ENG-PUDSP21010-R3-TIS.pdf Markup Summary

the other previous studies also assumed fewer dwelling units on this site.
Topic: updated Eastonville Road Project Conceptual Design Report with
the Eastonville Road by Wilson & Company (Inc. of Pass County)
AND ACCESS
For clarity, it should be mentioned
that the church site includes both
a church and a daycare center.
has the proposed site plan for Phase 1 of Grandview Reserve. This is
clearly a 1/4 acre and is currently covered with a single tree
which is an "existing center" that is planned to include a 1/2
recreation center. At this time, there is no plan to phase construction
along with the land uses assumed for this later area in the Master Plan.

Figure 1
**Vicinity
Map**

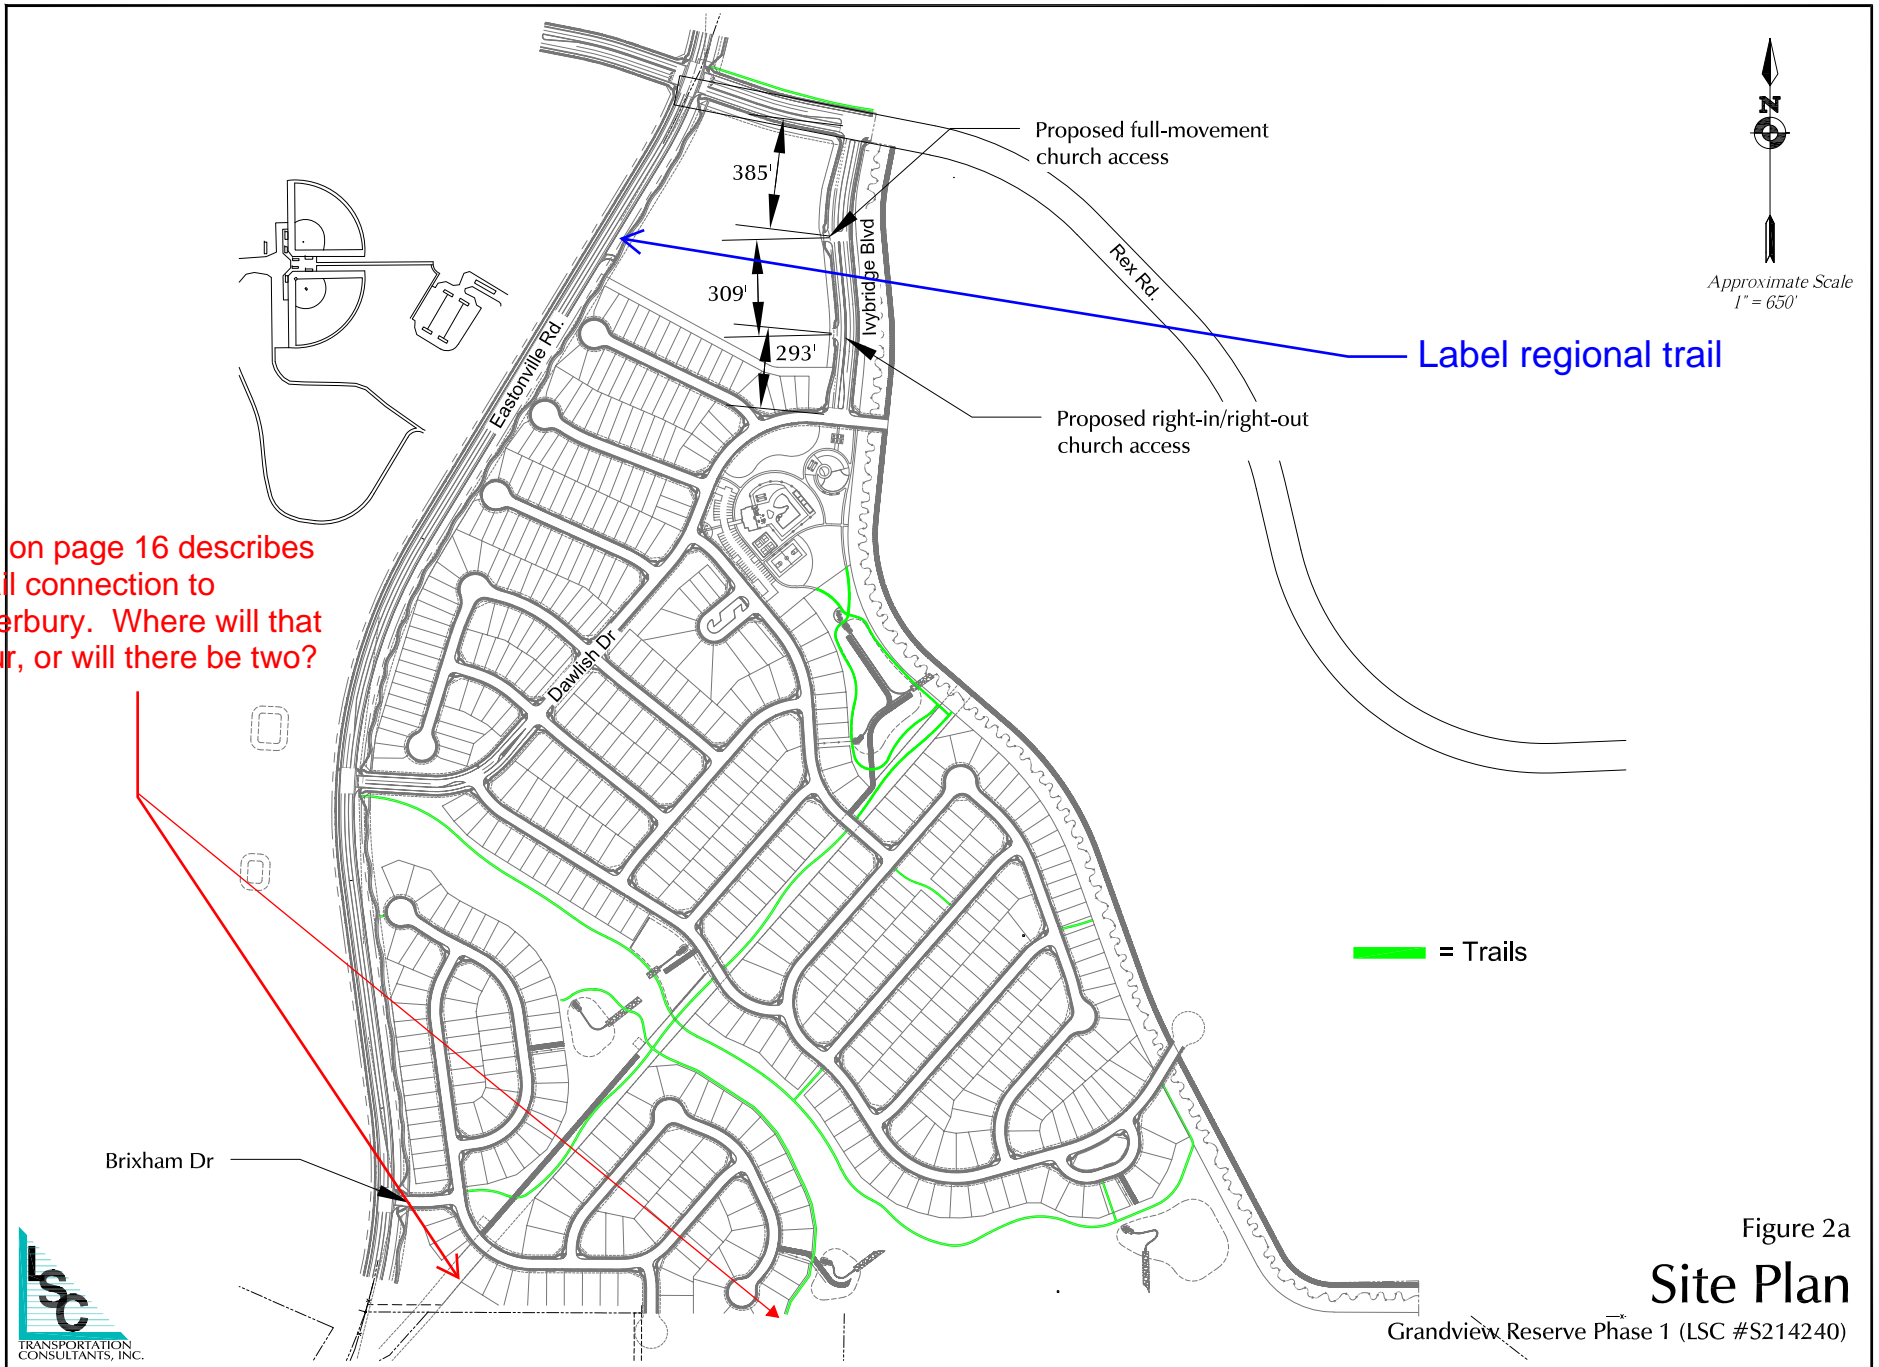
show park access drives

Figure 2b

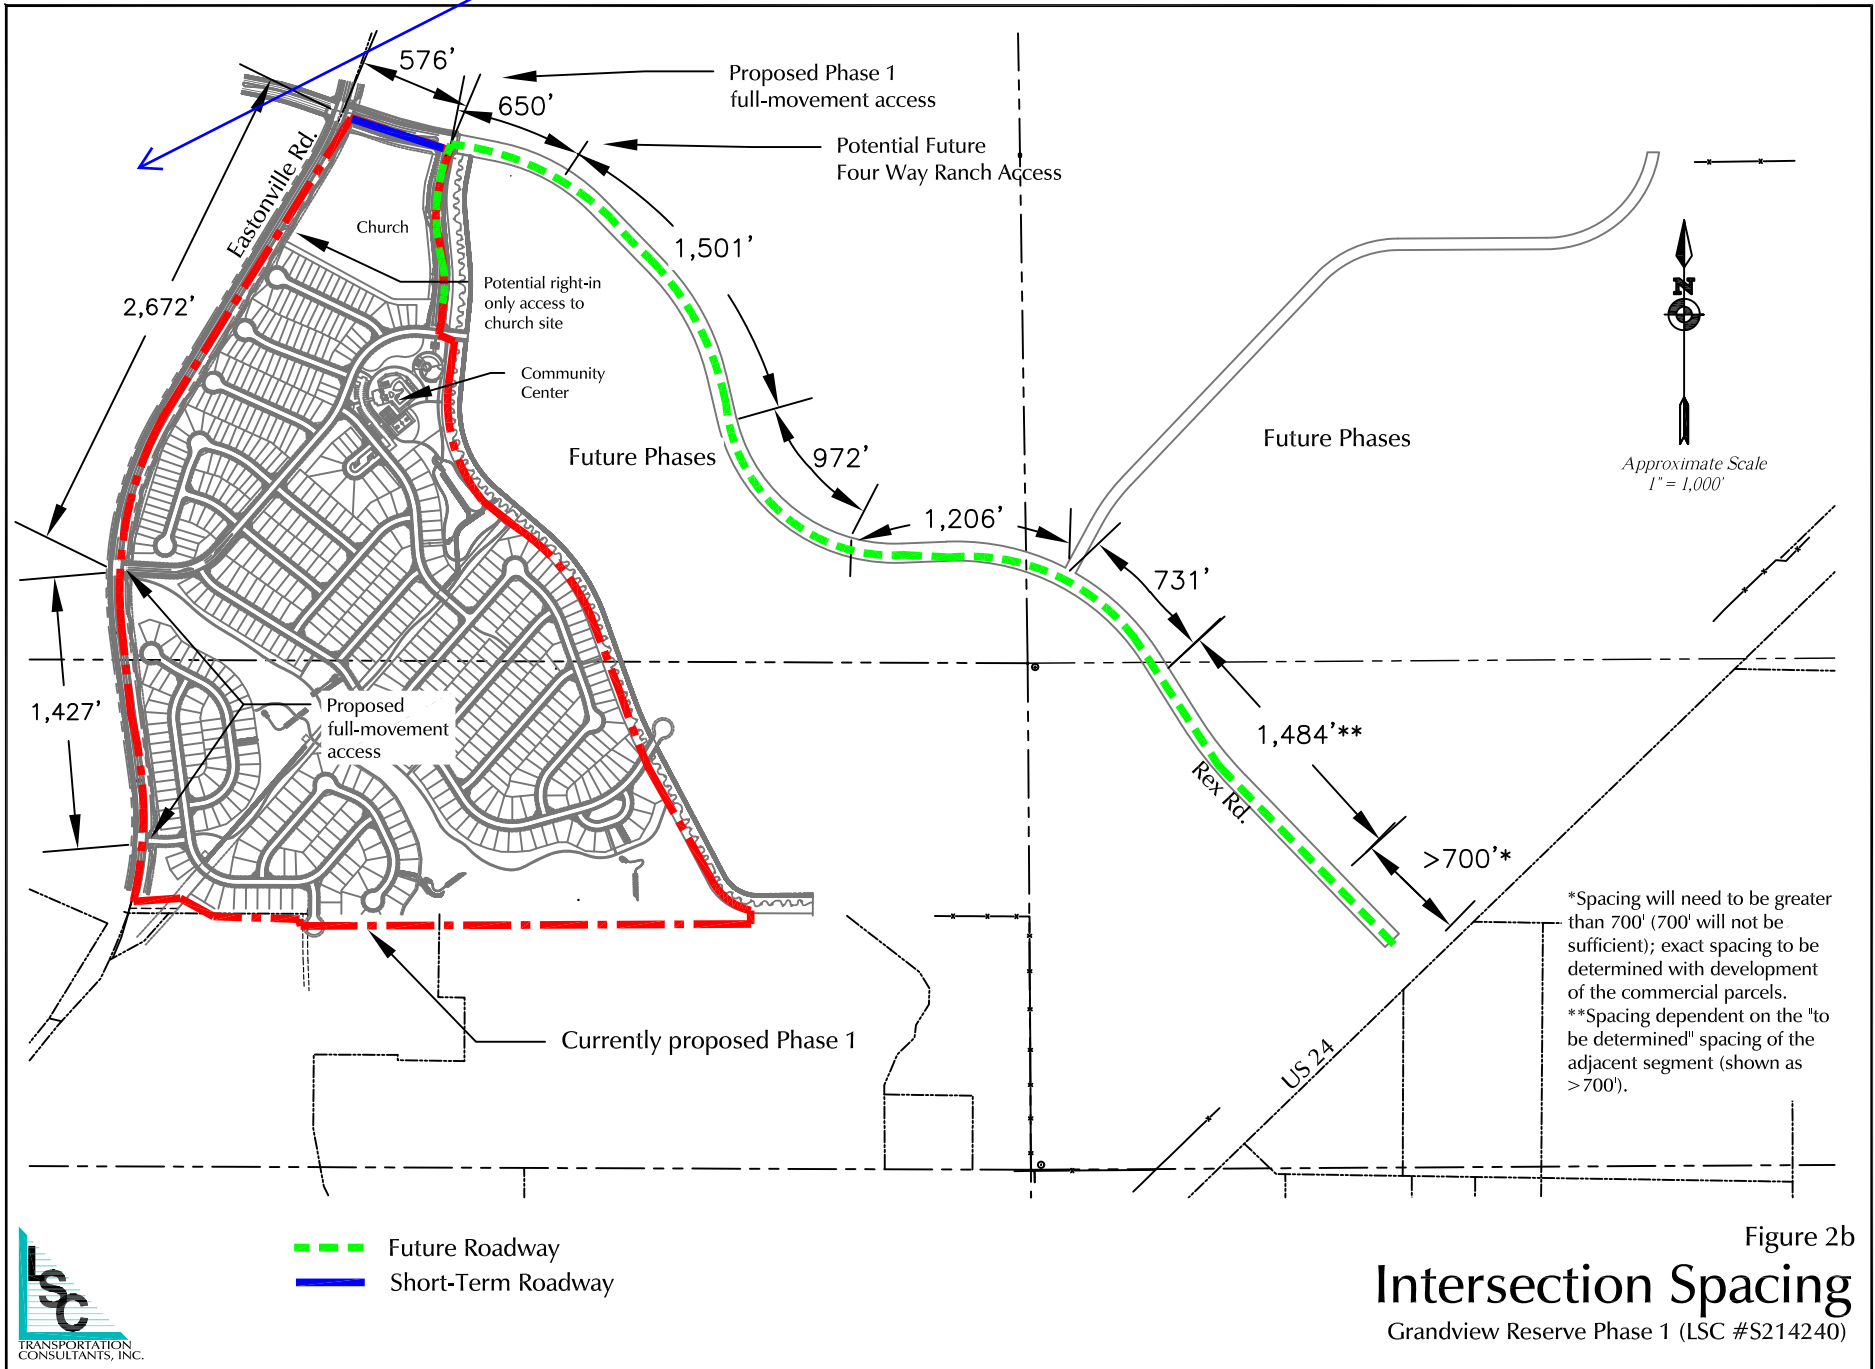
There are existing access points to Falcon Regional Park along Eastonville Road (refer to the ballparks shown on TIS Figure 2a). The TIS should consider how the proposed Grandview Reserve accesses interact with the existing park access (spacing, operations, etc.).

Figure 13

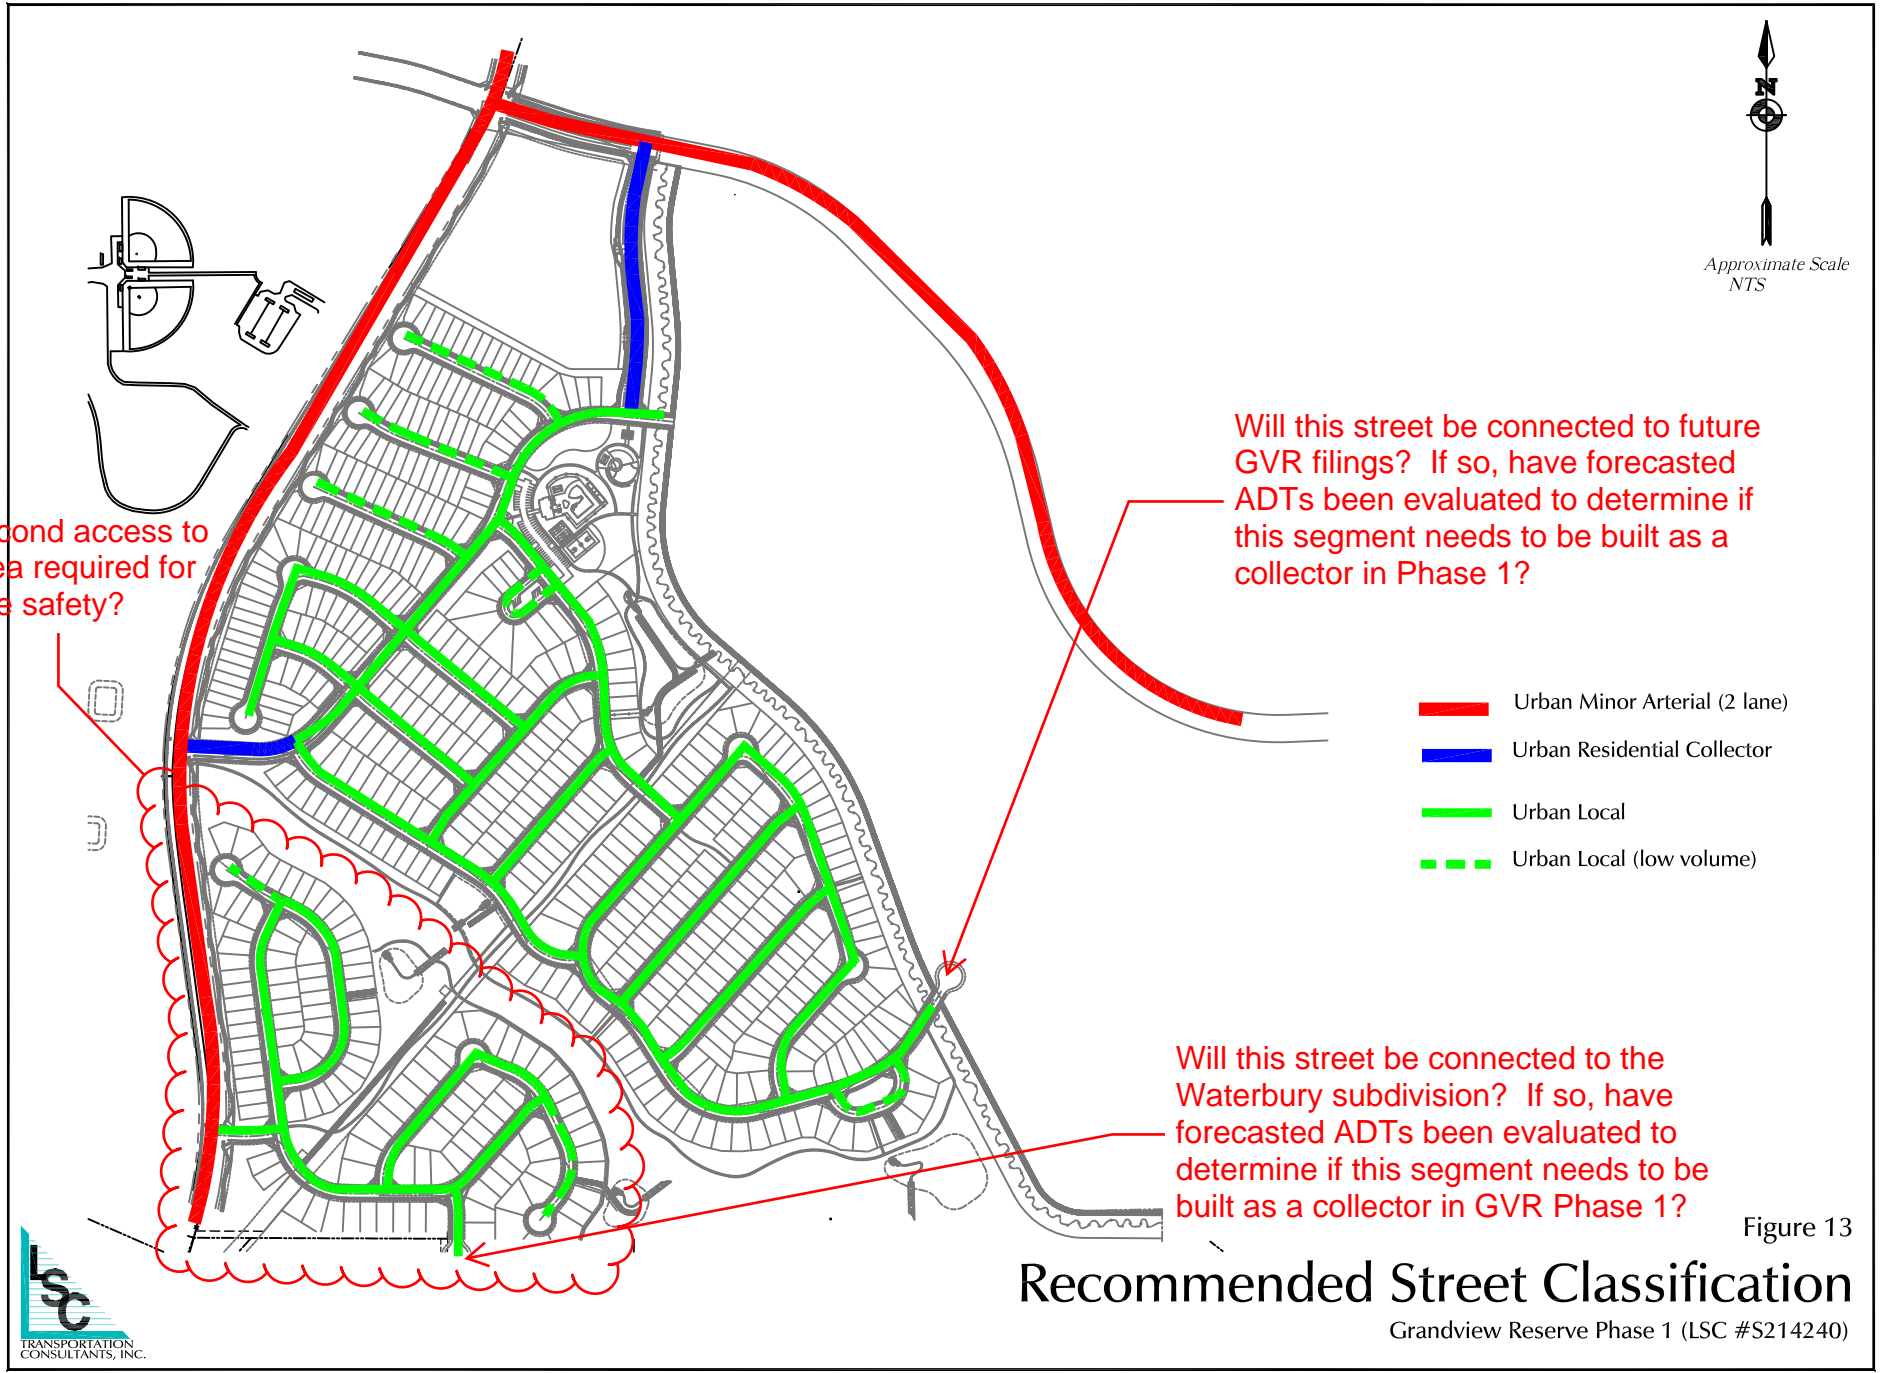
Will this street be connected to future GVR filings? If so, have forecasted ADTs been evaluated to determine if this segment needs to be built as a collector in Phase 1?

Will this street be connected to the Waterbury subdivision? If so, have forecasted ADTs been evaluated to determine if this segment needs to be built as a collector in GVR Phase 1?

Is a second access to this area required for fire / life safety?
